1 c) Roof Plant

Heritage Council Comment 1 c)

Figure 85b: Roof penetrations. Demolitions in red and Proposal in blue. Drawing by TZG.

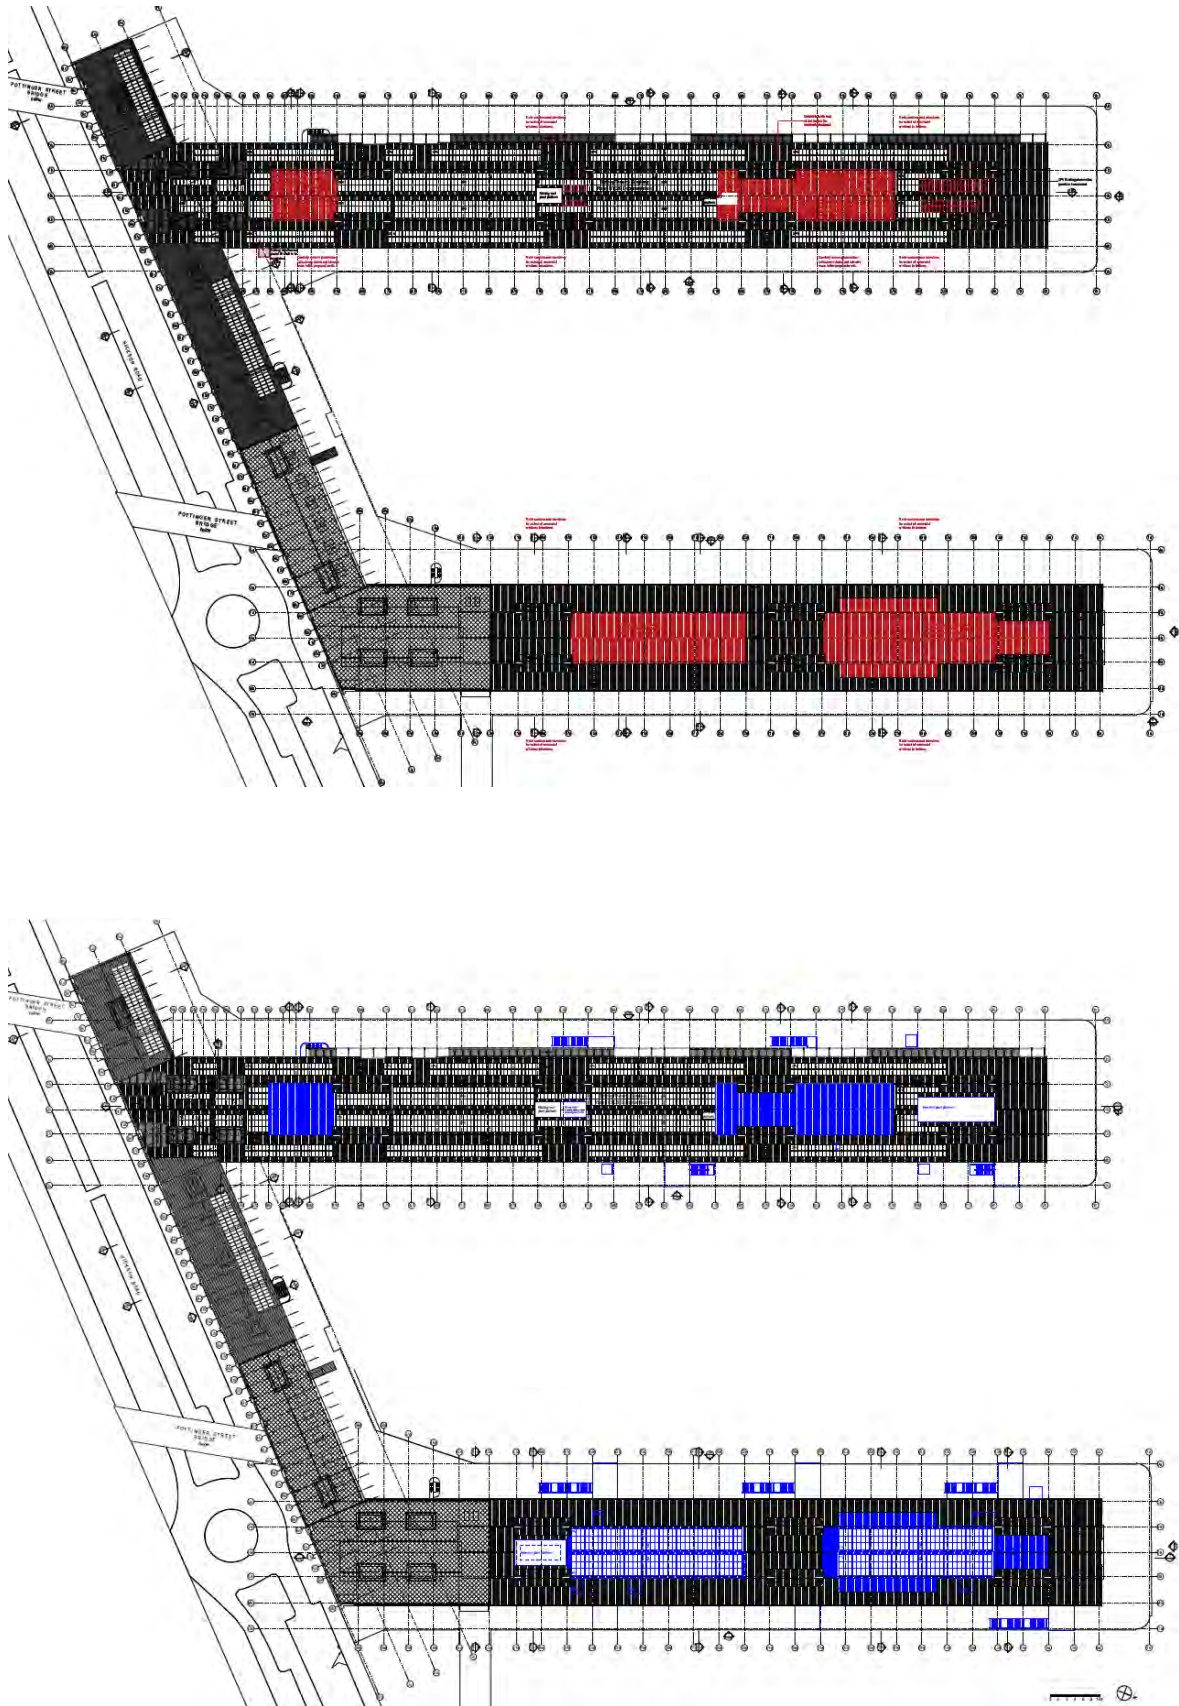
It is unclear if the proposed roof plant will be screened, in particular on Wharf 4/5. It is recommended that plant equipment is not visible from the public domain. Further design details for plant screening must be provided to the Heritage Council for assessment prior to approval of this project..

The external roof plant is proposed to be located on simple steel framed platforms set in the valleys, between the two ridge lines, to ensure that it will not be visible from the public domain. It is not proposed to be screened.

The Visual Impact Assessment that accompanies the proposal, demonstrates that the roof plant will only be visible from above – from the Harbour Bridge and higher areas of Millers Point – as per the existing roof plant on Wharf 4/5, and will not compromise appreciation of the heritage significance of the place. Oblique views will not be possible, therefore screening would not prevent views from these angles.
